## Development Facilitation Team (DFT) – Review Comments

**Project No: PR-2024-009995      Date: 03/27/2024      Agenda Item: #1      Zone Atlas Page: N-15, P-15**

**Request: Waiver to Underground Requirement of New Electric Distribution Feeders**

### **Application for: VA-2024-00036 - WAIVER TO IDO**

Prosperity Feeder 11

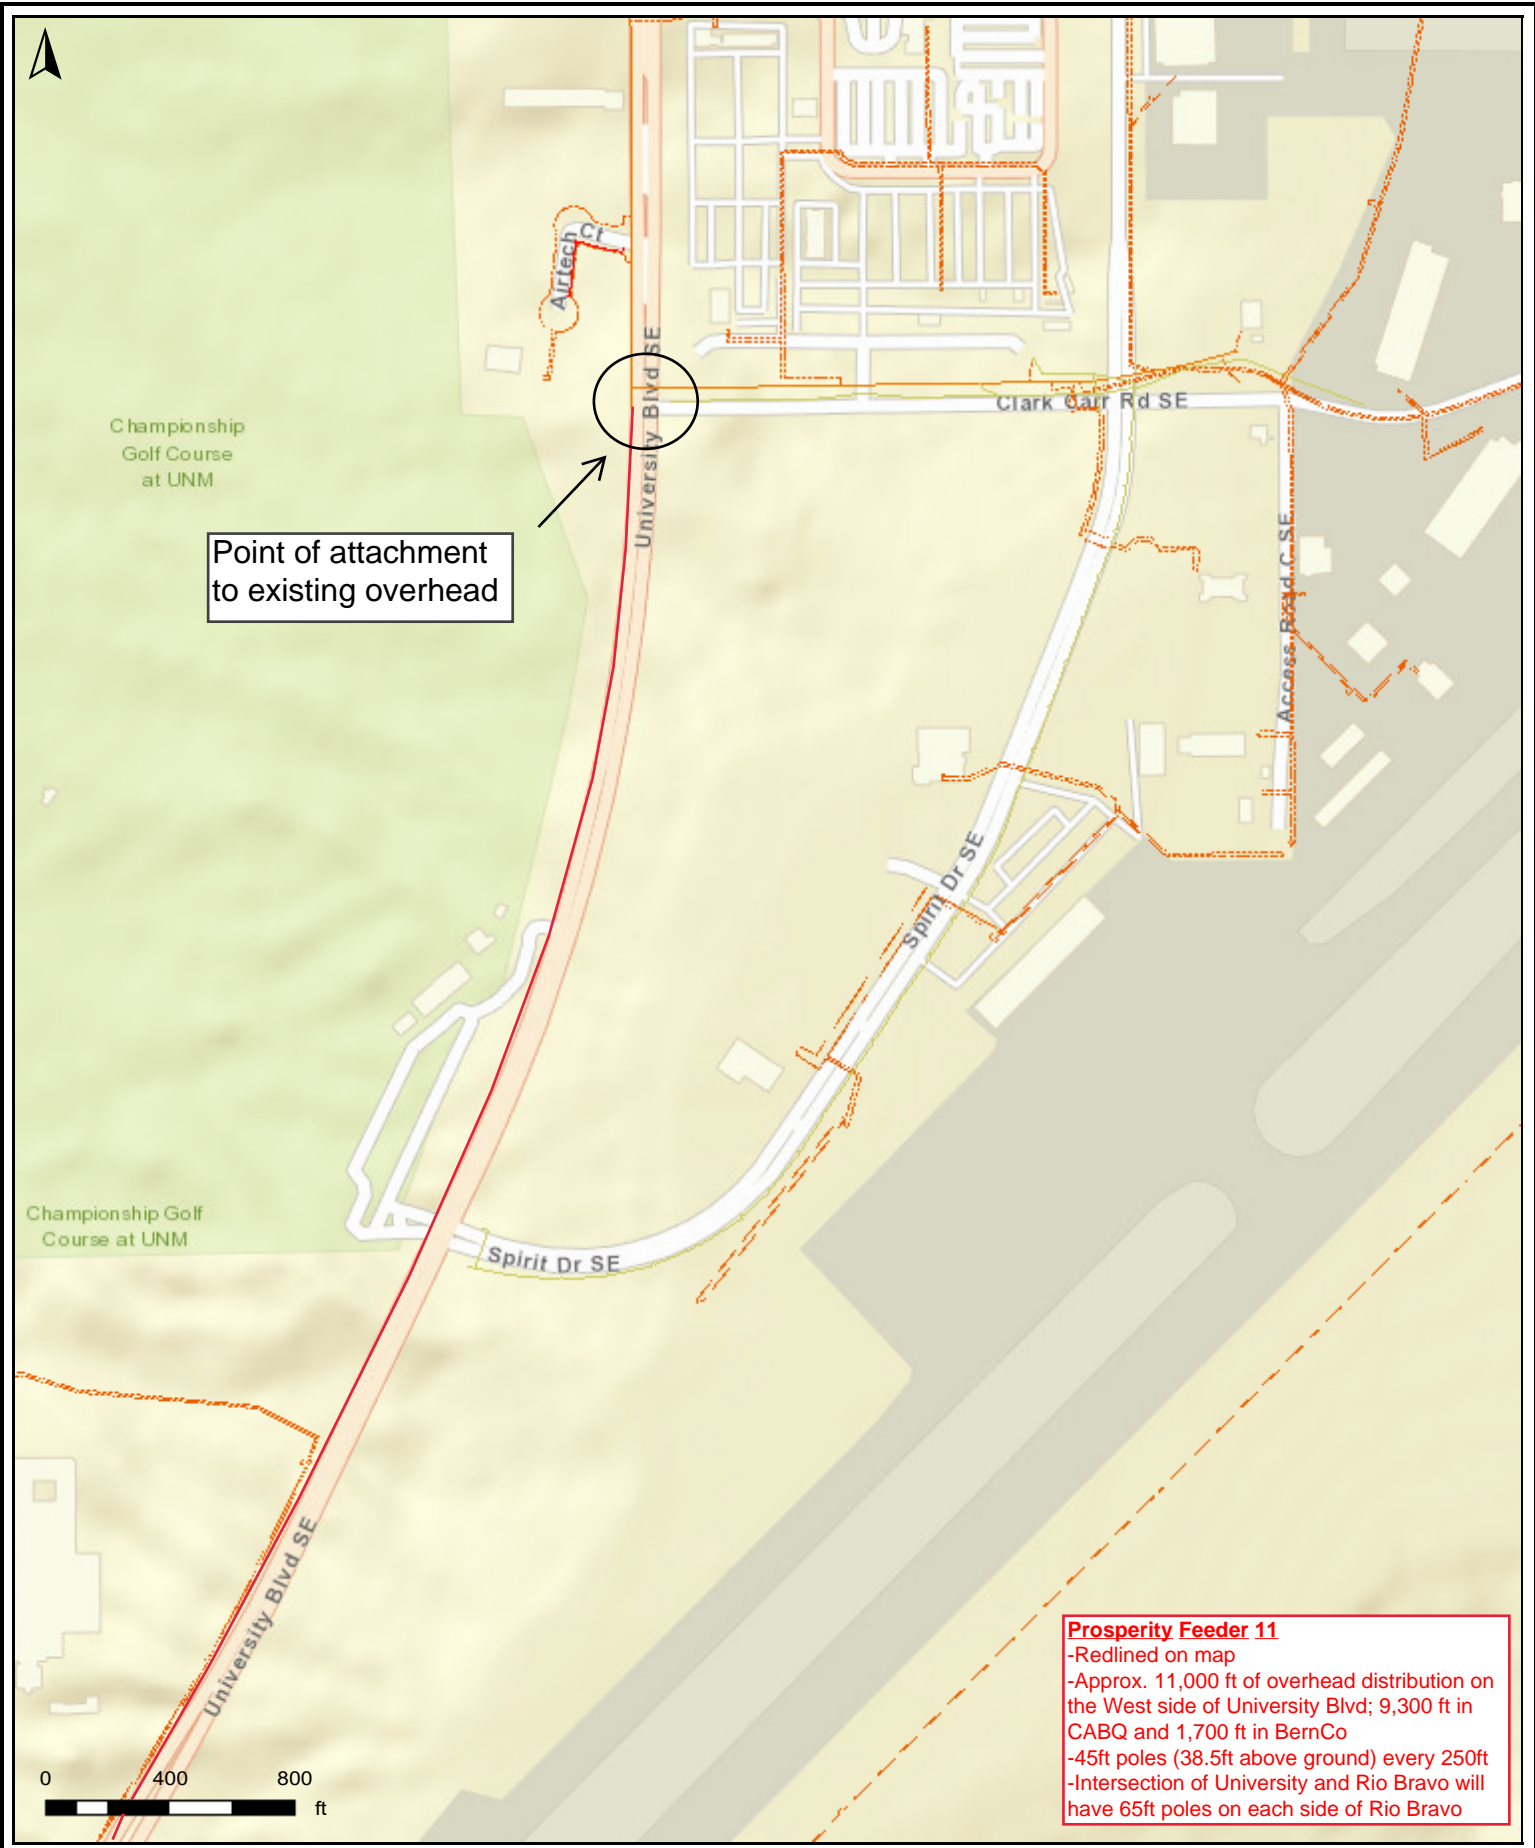
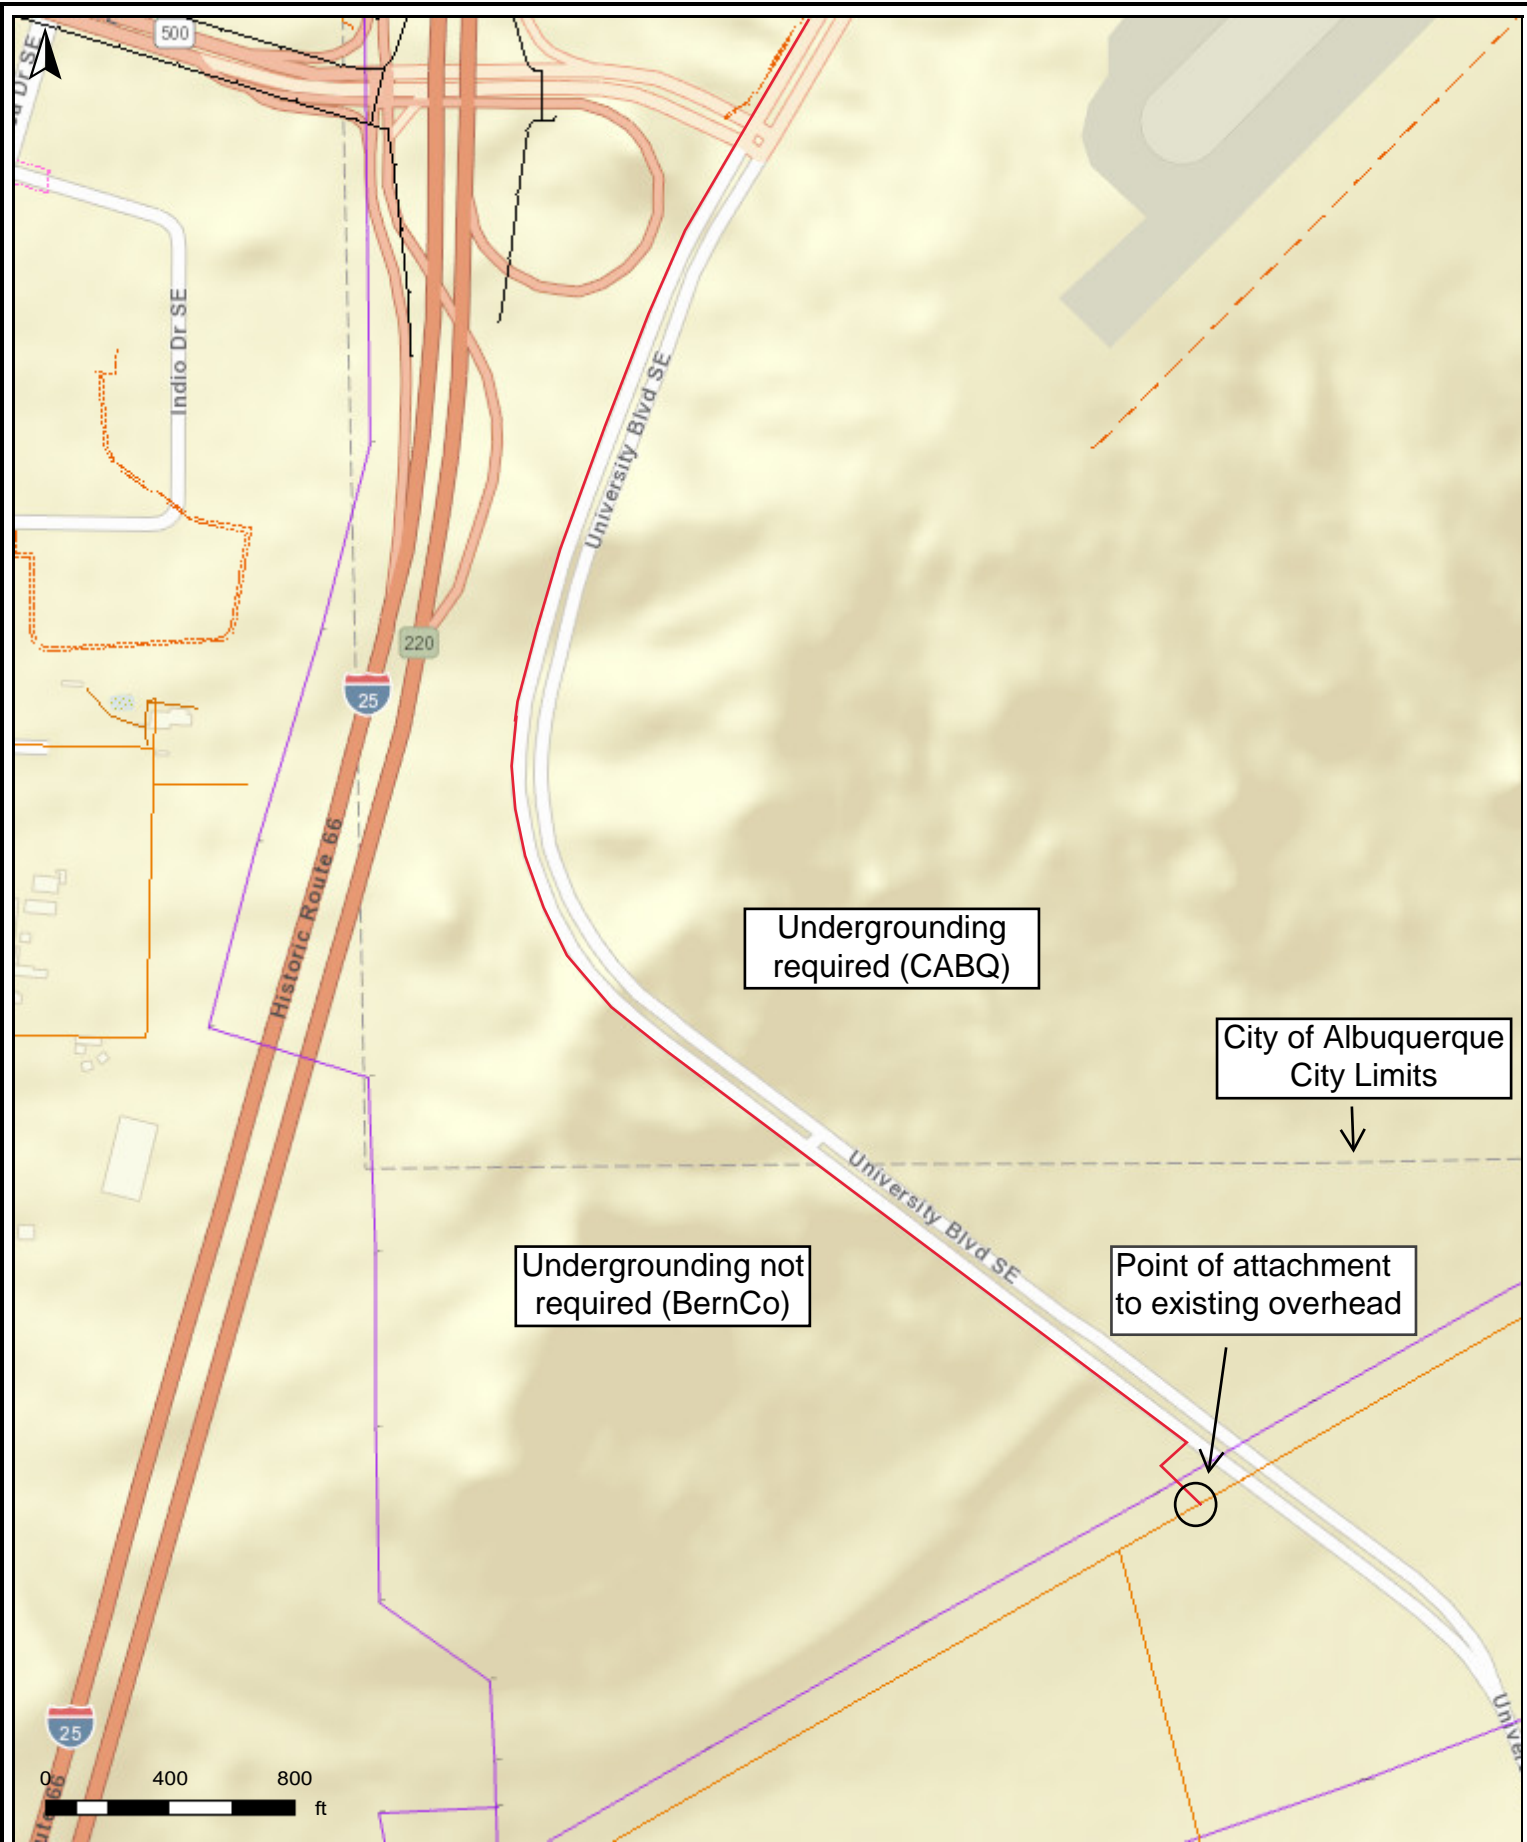
- a. Line spots will be necessary as well as the potential need for potholes to acquire a sufficient layout.
2. Without further detail and survey information the Water Authority cannot make recommendations and will need an exhibit to be provided that includes proposed locations of poles, a detail at each location of how far the non-potable waterline is from each proposed pole along with a trench prism to show potential excavation affects of any proposed poles.

1. Right-of-way on the west side of University appears to be pretty tight in several locations and the City has a multi-use trail on this side of the road. All poles would need to avoid the trail and any other City facilities along the roadway.
2. Please provide a diagram showing the right-of-way, roadway, trail and proposed location of your powerline at a scale where it is visible how the poles will sit in relation to the trail to help determine if this is possible.

2. **WUA water line.** The placement of overhead lines on the west side of the University likely conflicts with the non-potable water lines already in place on the west side of the University. WUA staff's informed supposition is that they are most likely under the trail when on the west side of University, but this is not true all along the corridor. (See the three graphics below of sections of University with the non-potable water line roughed out in blue.)

The applicant has failed to analyze how the distribution lines would fit into the existing ROW where PNM has its franchise agreement to place this utility. The 'as-built' conditions, line spots, and/or potholes are required to guarantee there are no conflicts. The power poles cannot be placed on top of the water easement because they would interfere with maintenance and create unsafe conditions for maintenance. The easement is the water line and 7 feet of clearance from the water line to any power pole. PNM may be able to show that there is space for the electric line in the ROW on the west of University and some of that information could be presented at the hearing.

3. **Multi-Use Trail.** There is a multi-use trail from Clark Carr to Los Picaros on the west side of University. The overhead lines could be contrary to the recreational value of the trail. Parks and Recreation has indicated that a 2- foot clearance on each side of the trail must be kept for safety and maintenance. The applicant has not shown the 'as-builts' for University Avenue which would show if there is adequate room for above ground poles with proper safety clearance to the trail. Air photos show that the fencing, which may or may not indicate the ROW, is abutting the trail on the west in some locations. Undergrounding would serve a public purpose to preserve the multi-use trail in this corridor.

4. The west side of University includes the UNM Championship golf course and Jabill business. The Jabill business is the only segment where there is mature landscaping, i.e., a row a mature, tall trees adjacent to the sidewalk/trail. The second PNM submittal shows a rerouting of the overhead lines to avoid the Jabill site which would be necessary. The overhead distribution lines and poles would have a somewhat negative aesthetic effect on the UNM Golf Course or any other development anticipated by UNM for this area.
